18 December 2025

RFI Response – Crescent Parklands, Holroyd (SSD-70283710)

This letter relates to State Significant Development Application SSD-70283710 for the proposed mixed-use precinct development, including seven residential tower buildings, an eastern mixed-use podium and associated car parking at 1 Crescent Street, Holroyd (**the site**).

Figure 10: MUSIC Model and Results

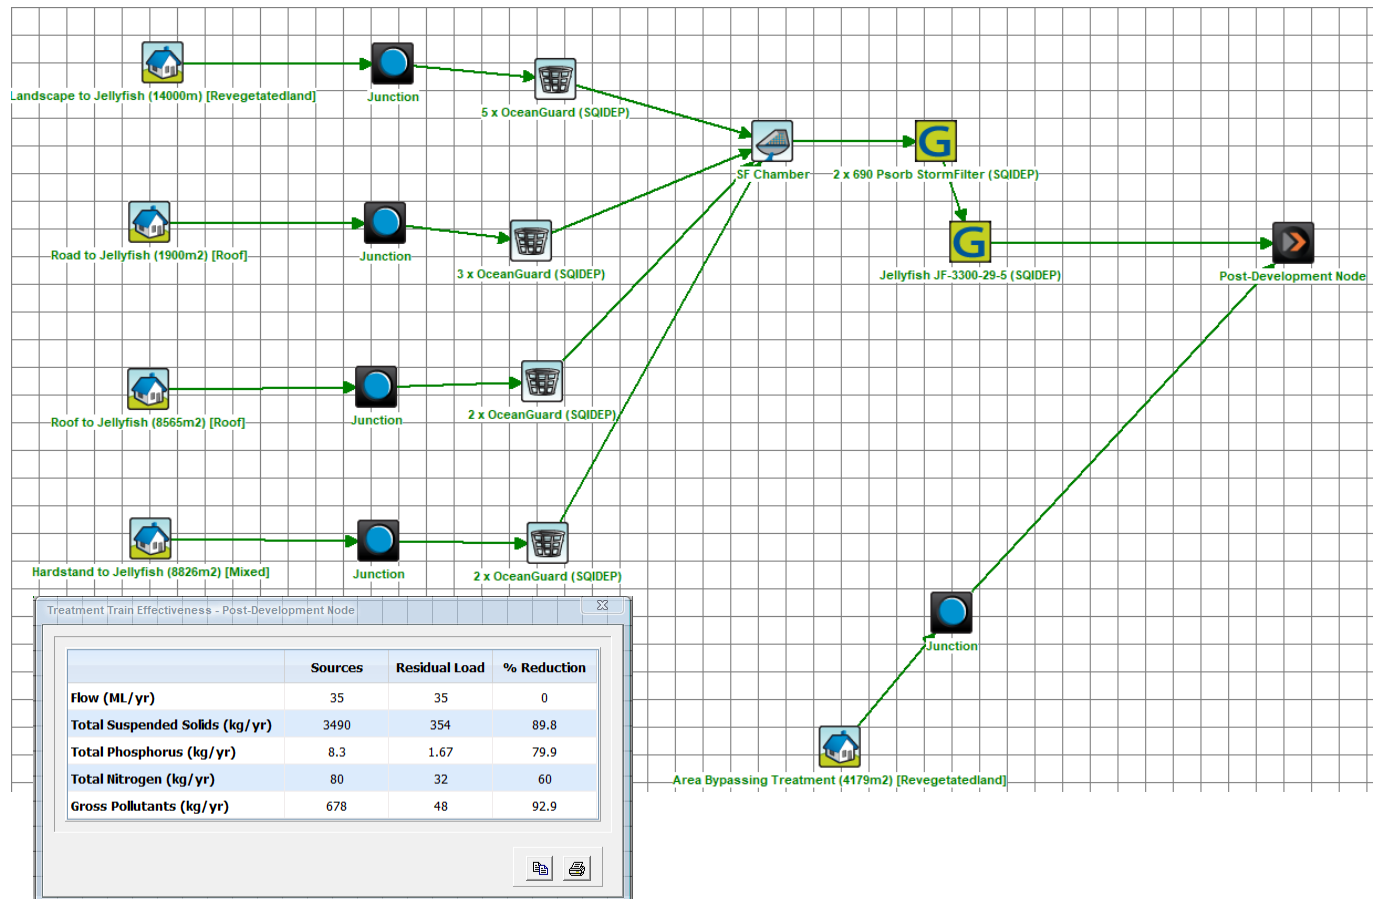
The MUSIC model should be consistent with and reflect the treatment system components (water quality treatment devices) as proposed and shown on the plan.	The MUSIC model is consistent with and reflects the treatment system components (water quality treatment devices) as proposed and shown on the plan.
The provision needs to be re-assessed, and further comment will be made upon receipt of the MUSIC model.	Noted
Electronic copy of the MUSIC model adopted has not been provided. The provision needs to be reassessed upon receipt of the model.	Noted
Landscaping	
The Landscape Concept Plan prepare by Arcadia provides an overview of the landscape plan for the site but lack details such a precise location of proposed species, quantity etc. A condition has been recommended in Attachment B.	Noted - the proponent is in agreement for DPHI to impose a suitable condition of consent to resolve this matter.

TITLE DRAINAGE GROUND FLOOR SHEET 2 OF 4		
PROJECT No. S22215	DRAWING No. CI-0302	REV G

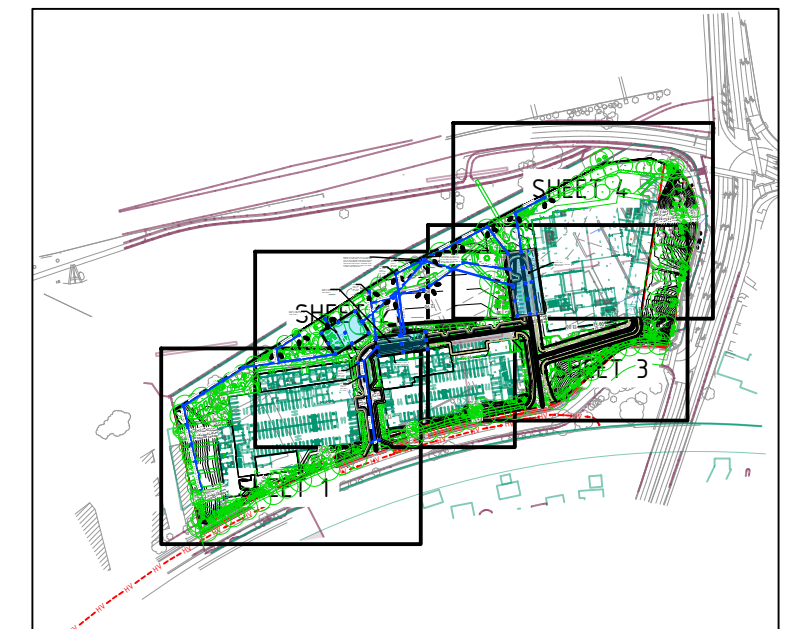
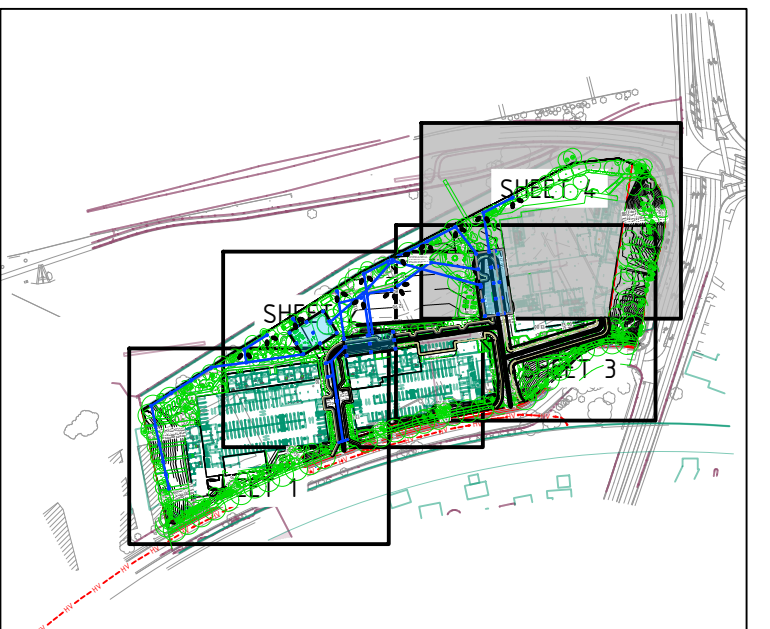
Council Comment	Response
Stormwater Management	
The sub-catchment area for each OSD system associated to the OSD system should be delineated on the plan and the area shown in m ² . The OSD sub-catchment delineation/demarcation and the area has not been provided.	The OSD sub-catchment delineation/demarcation and the area has been added to the civil plans, refer to Appendix A.
The OSD design calculation summary sheet for each of the OSD systems should also be provided. The provision of OSD storage for each catchment must be based on the sub catchment area. The information provided is incomplete. The OSD design calculation summary sheets have not been provided.	The OSD design calculation summary sheet for each of the OSD systems has been provided in Appendix DD of the SARs.
The cross-sectional details of the OSD tanks including the levels and storage volume have not been provided. The cross sectional details shown but lack the orifice centreline levels, and the overflow outlet level that controls the top water level within the tank. The numbers/figures stated in section 6.4 of the Stormwater report are not consistent with that shown on the sectional detail drawings.	These sections have been provided in Appendix DD of the SARs. The sections clearly, show the levels and volumes. Overflow outlet grate levels and top water levels are shown on plan and noted in the tank summary as well

TITLE		
OSD PLAN AND SECTION		
OSD TANK 3		
PROJECT No. S22215	DRAWING No. CI-0352	REV D

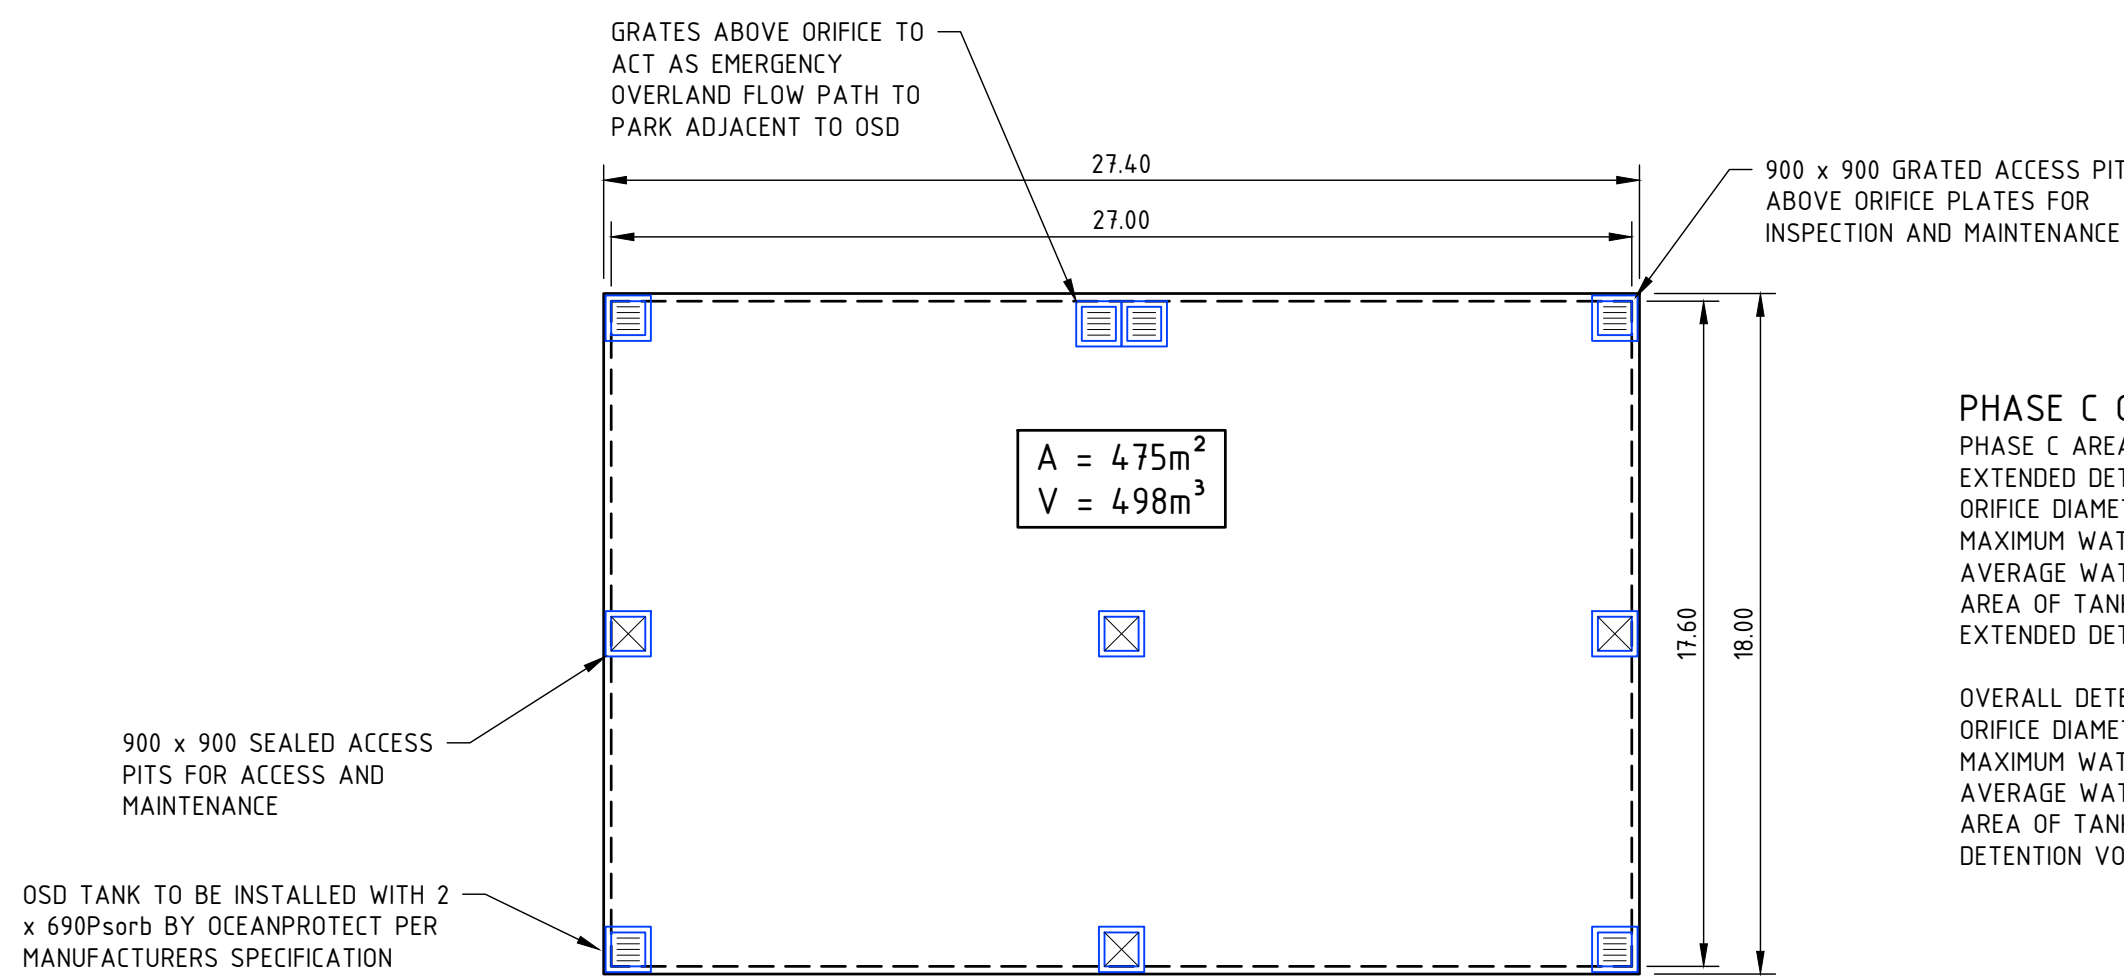
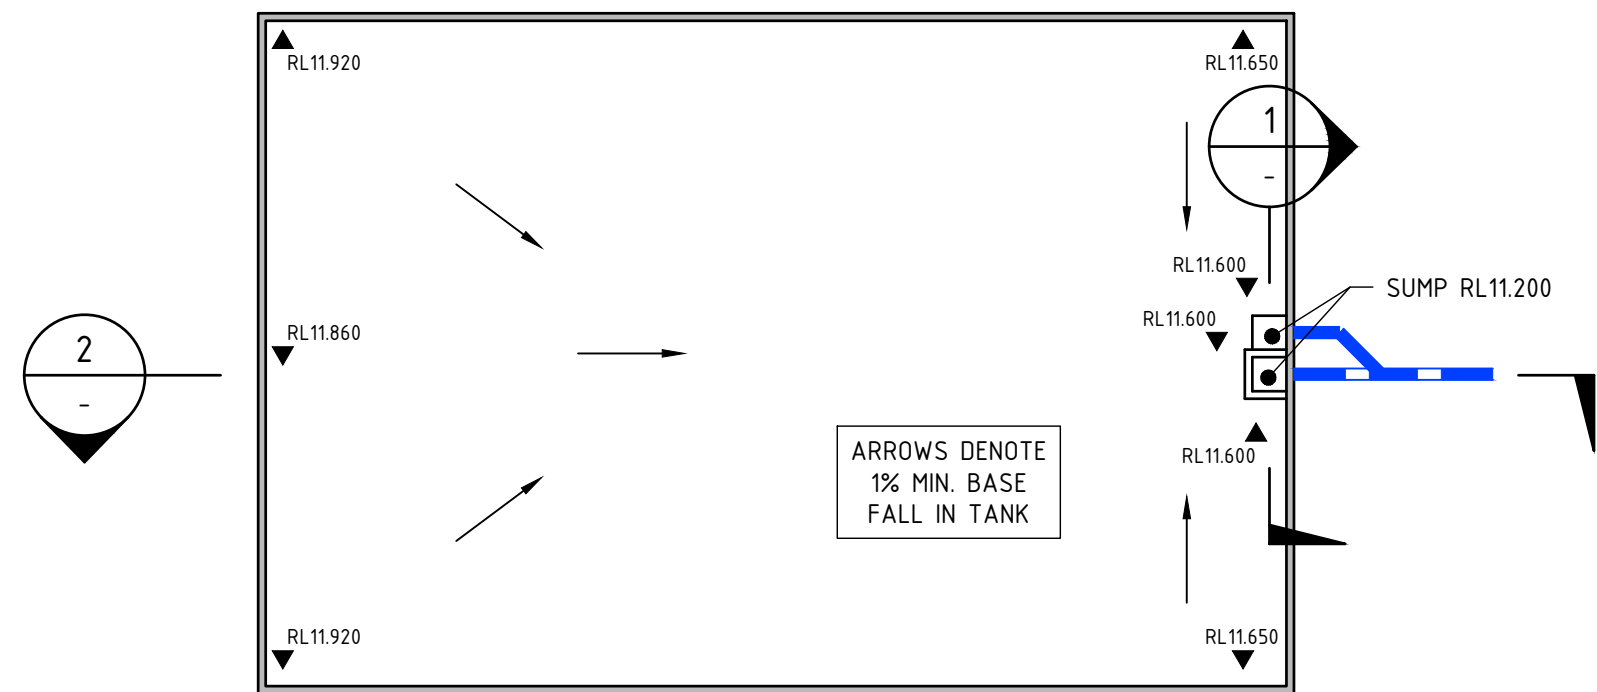
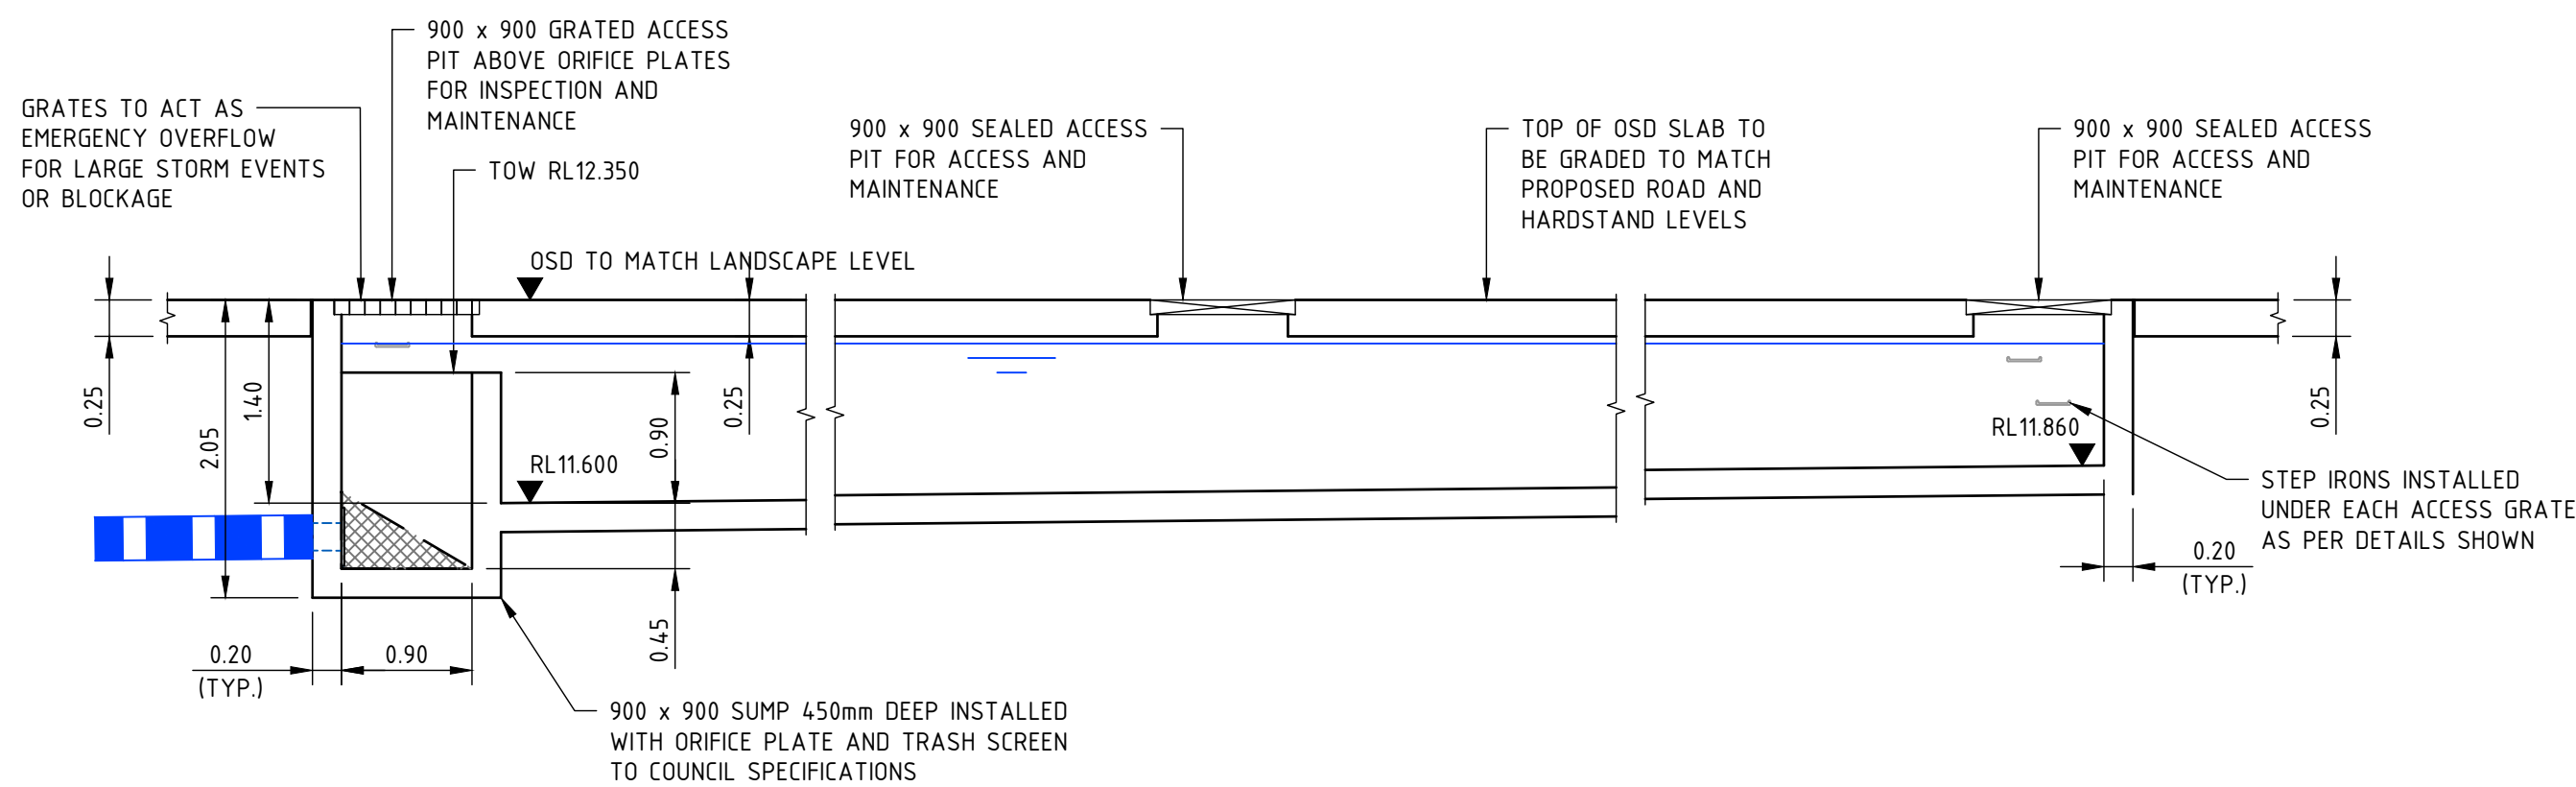
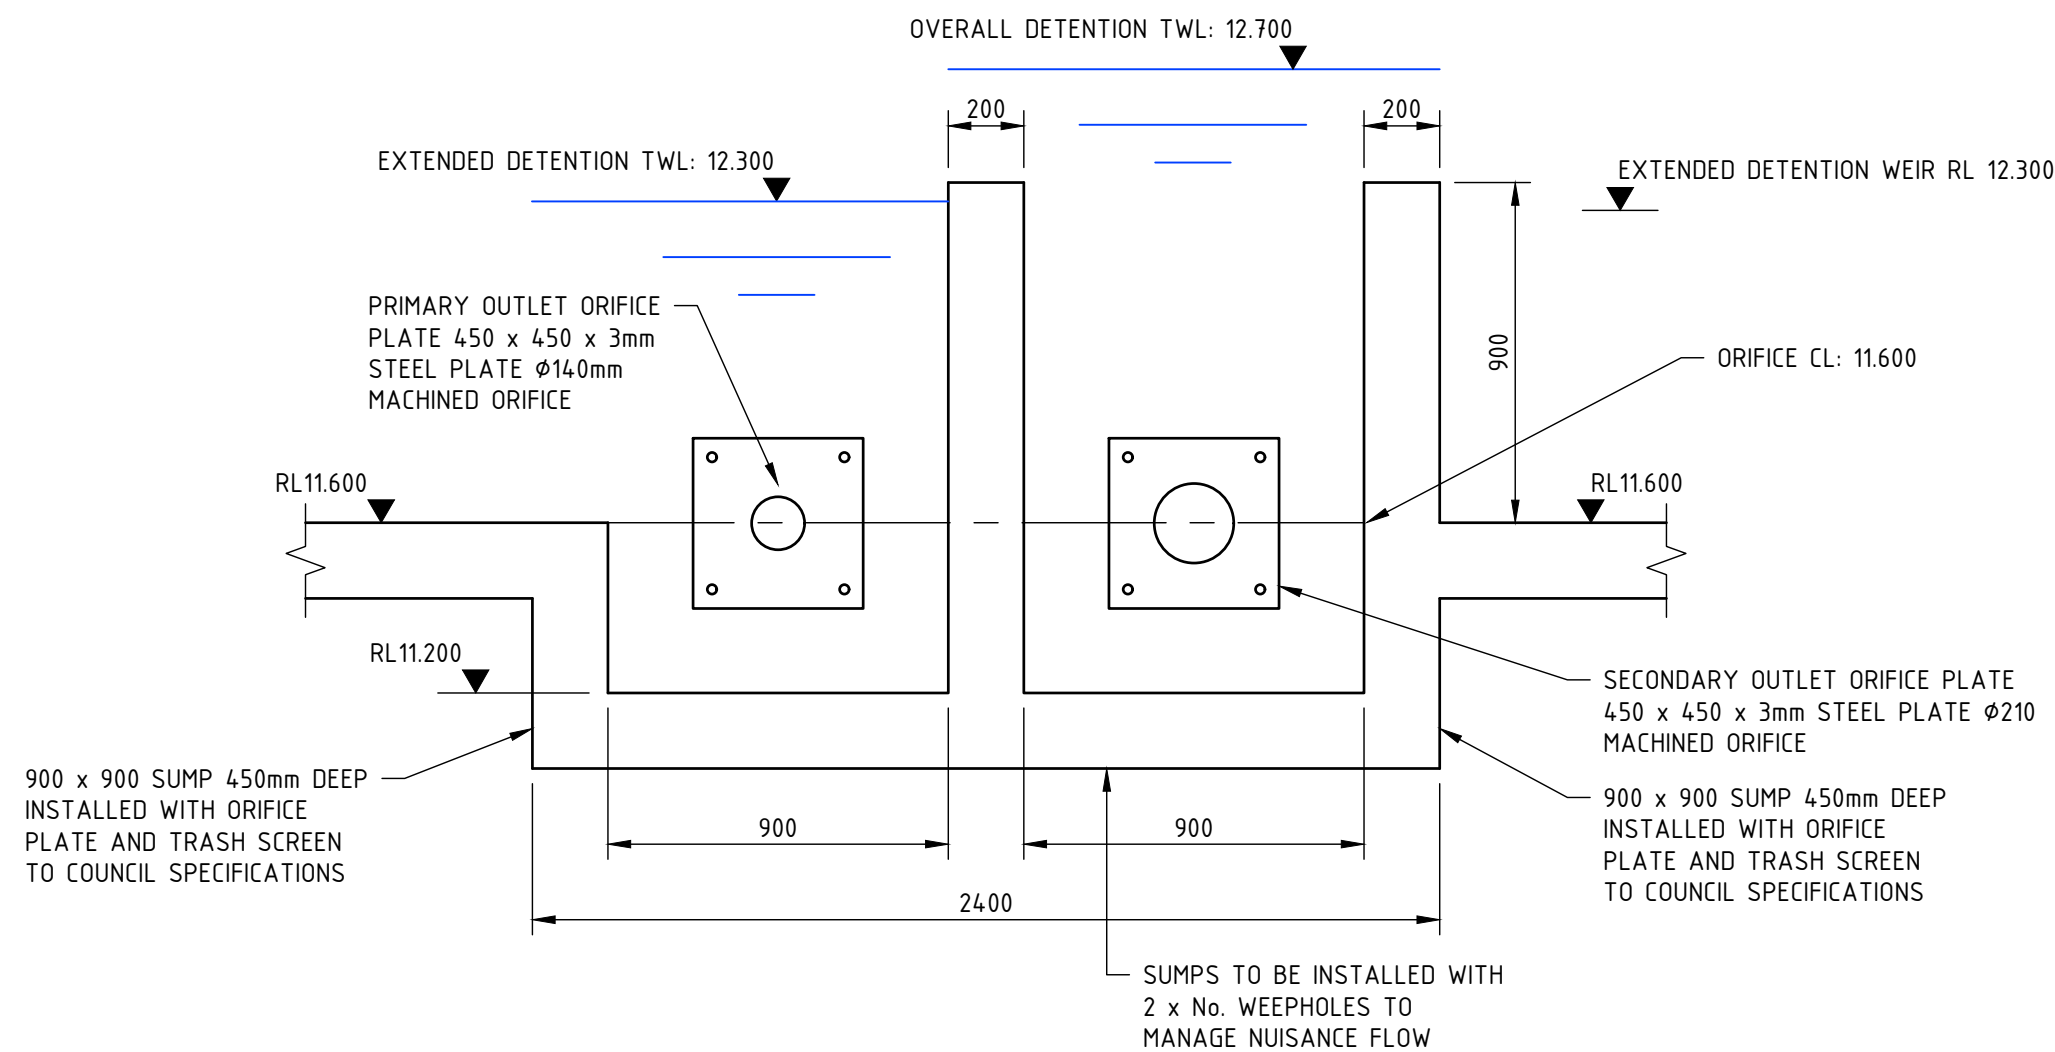
Based on the available information, the available OSD storage volume appears to be insufficient. Particularly the available OSD storage volume from the OSD tank 2 appears to be 345m ³ , noting that average depth of 0.7m only based on the slab inverts levels which varies from 12.3m to 12.55m. The average depth of 1m and storage volume of 410m ³ could not be comprehend.	Refer to Appendix DD of the SARs. The tank for stage 2 is called up as phase B OSD tank with an area of 407m ² . The depth, area and volume information is provided in the summary notes adjacent to the tank
The OSD Total storage calculated for Stage B appears to be underestimated and insufficient. In addition, the total OSD storage provision for stage C appears to be insufficient and the numbers shown area not consistent (area calculated appears to be incorrect).	For Stage C, the tank area contains a typographical error, which will be corrected to reflect the accurate calculation. For Stage B, the storage provision is sufficient when assessed against the relevant phase area.
